## **Suffolk County Council (20041323)**

Comments on any other submissions received  
at Deadline 9

## **Bramford to Twinstead (EN020002)**

Deadline 10

Reproduced from Ordnance Survey maps by permission of the Ordnance Survey on behalf of the Controller of Her Majesty's Stationery Office.  
 © Crown copyright Ordnance Survey, Licence no. 0100052046.

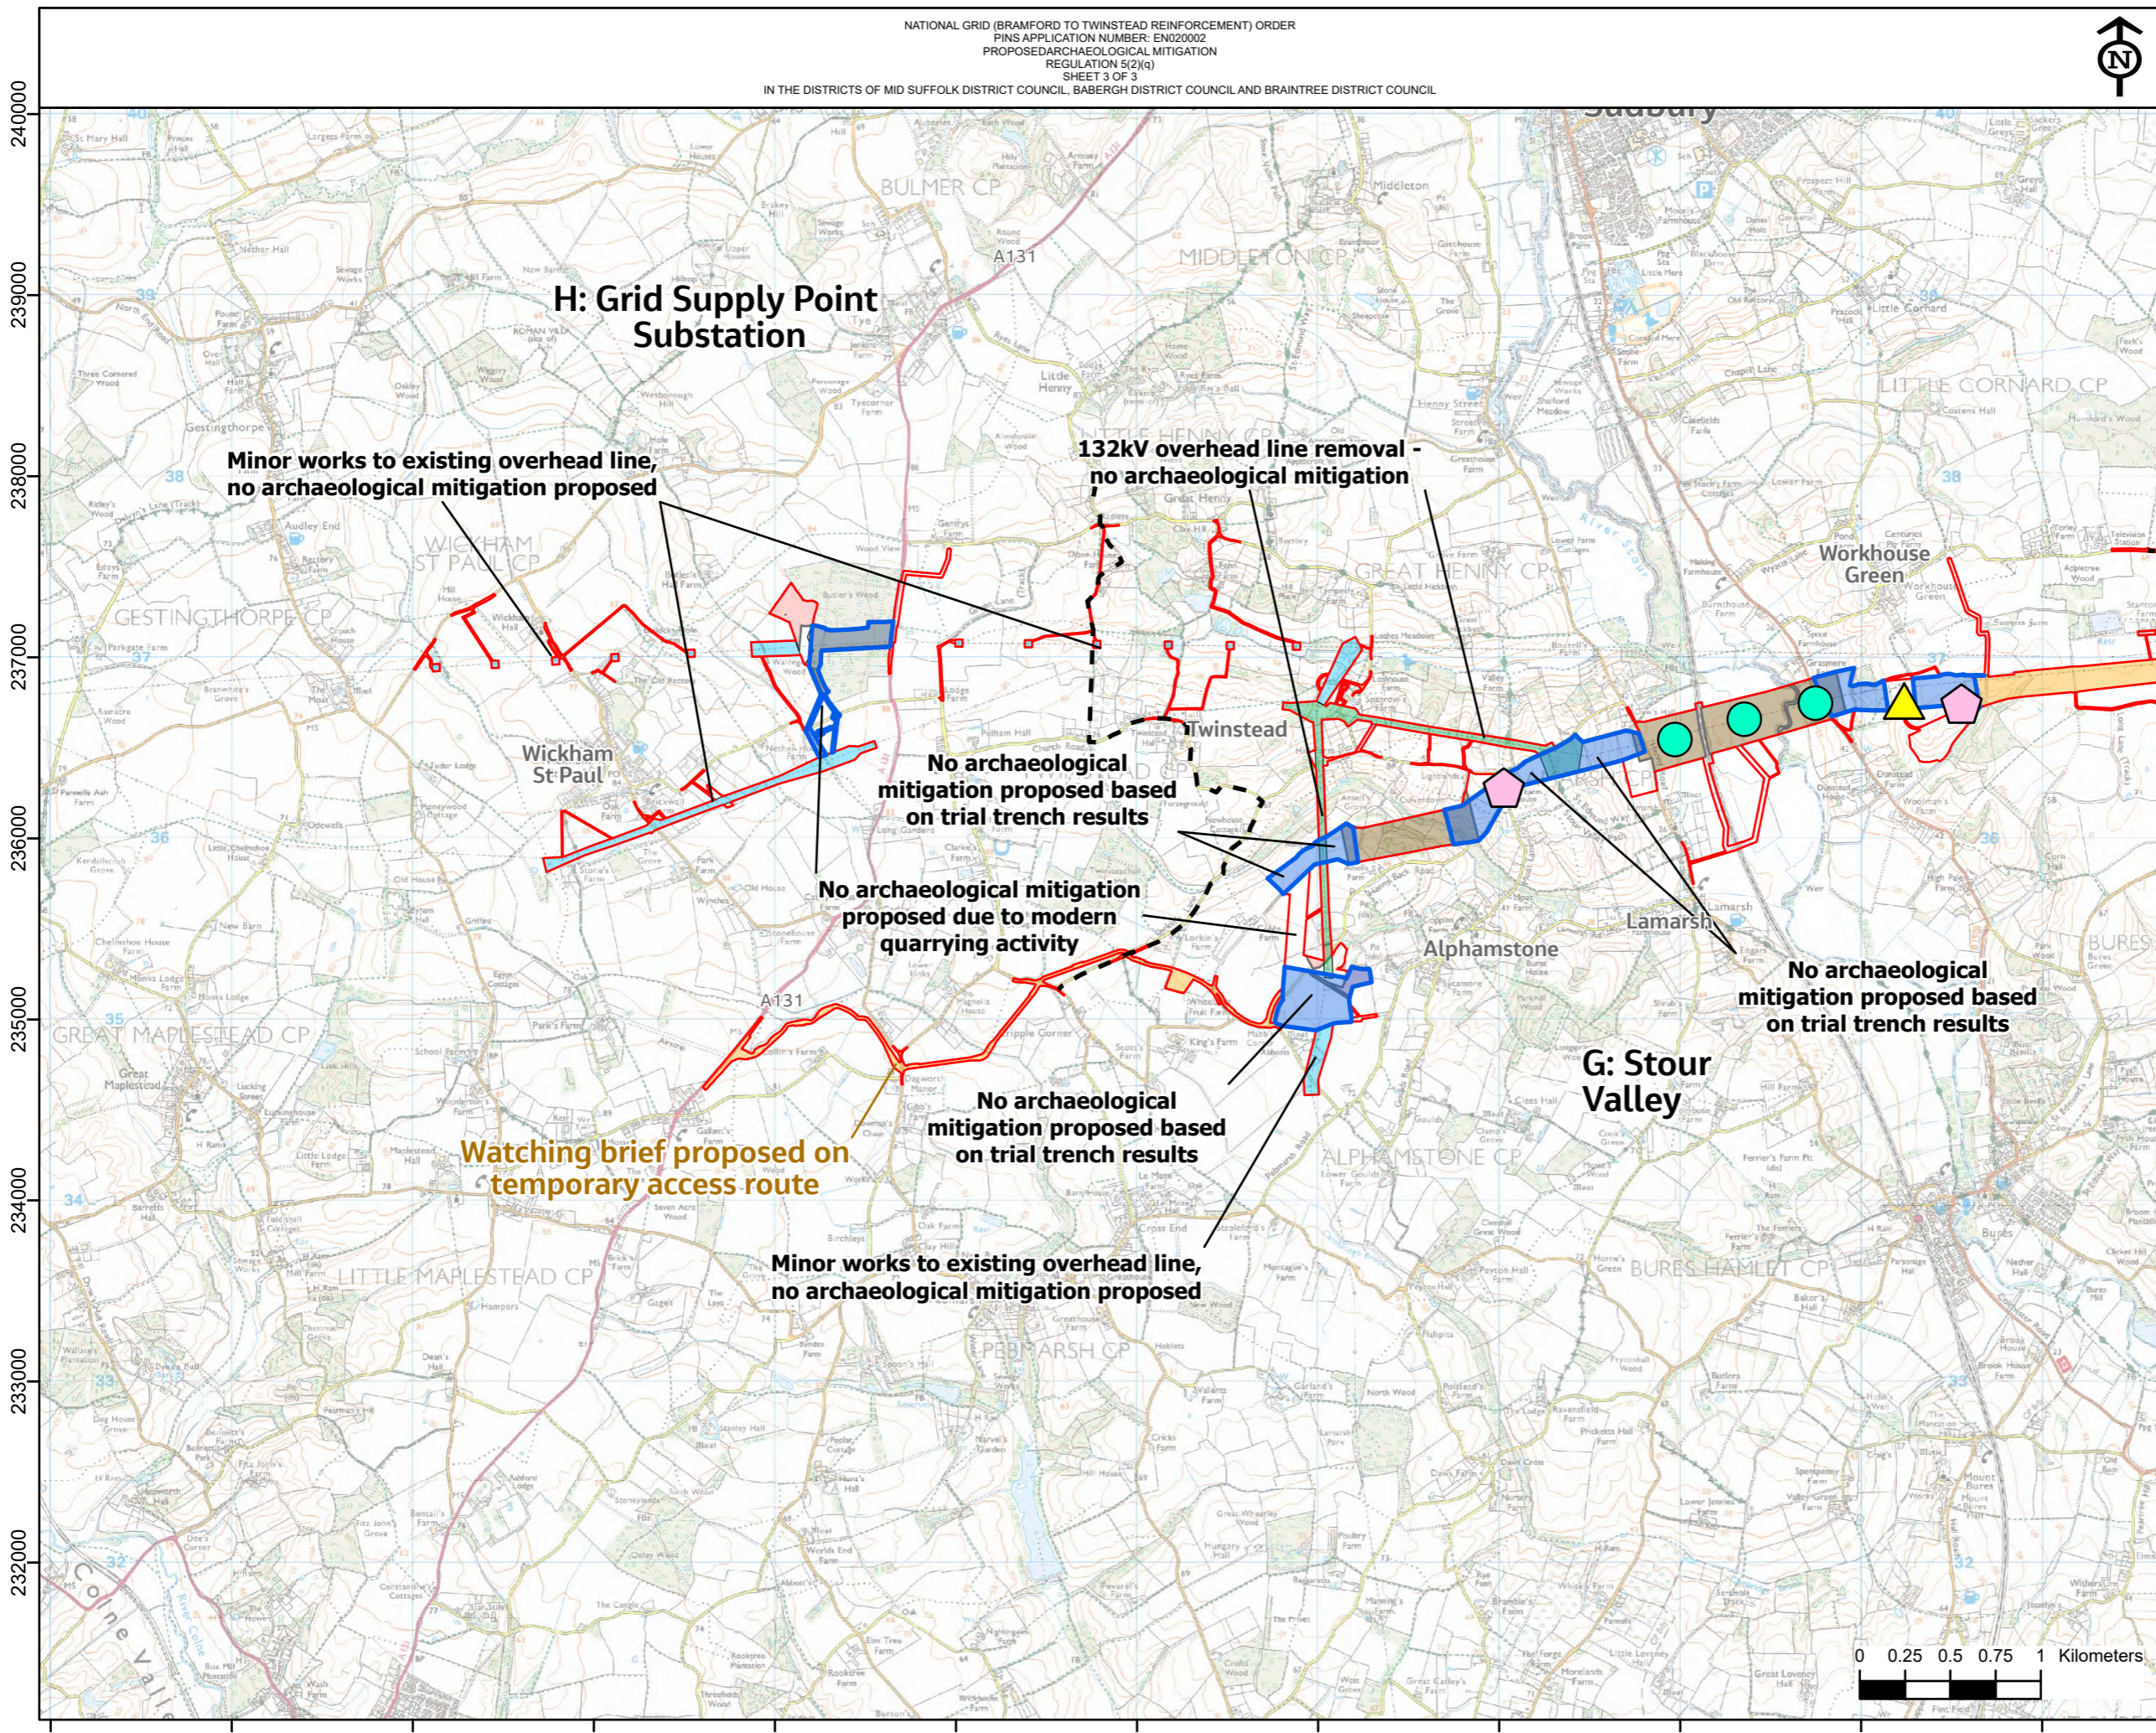
findings of each of the trenches.	
5c	Introduction - Aims and Objectives	1.3.3	<p>Archaeological mitigation is not proposed in the following areas (as shown on Figure 1: Proposed Archaeological Mitigation):</p> <ul style="list-style-type: none"> <li>• Locations where the 132kV or 400kV overhead lines are to be removed. The works in these areas will be limited to the pylon bases, which would have disturbed the soil during construction;</li> <li>• Modification works to the existing 132kV or 400kV overhead line. There will be works to the pylons and conductors of the existing overhead lines and in some areas adding arcing horns to the existing pylons. It is not anticipated that these works would require ground disturbance;</li> <li>• Area subject to a trenchless crossing. Although the drill pits are anticipated to be subject to archaeological mitigation, the line of the trenchless crossing would not be. This is because the trenchless crossings have been proposed in locations where the environment above the crossing is sensitive and the design has sought to avoid impacts to this</li> </ul>	<p>SCC (Archaeological Service) would note that in locations where overhead lines are to be removed there needs to be archaeological assessment to establish whether there will be impacts on any archaeology during the decommissioning and construction works.</p> <p>This would be for compounds, pylon construction areas and access routes constructed to facilitate the removal and modification works. If so, in areas of ground disturbance appropriate levels of archaeological evaluation will be required to determine the impact of the proposal on archaeology.</p> <p>For modification works, construction compound/storage area locations would need to be assessed and mitigated appropriately.</p> <p>The area of the trenchless crossing is to be subject to geoarchaeological and palaeoenvironmental archaeological assessment, providing deposit models and palaeoenvironmental information, to determine the level of mitigation (if required) on sensitive deposits of archaeological importance that would be damaged or destroyed by the proposed trenchless crossing. Therefore, there is archaeological mitigation proposed for the trenchless river crossing areas, and this section should be removed from 1.3.3.</p>
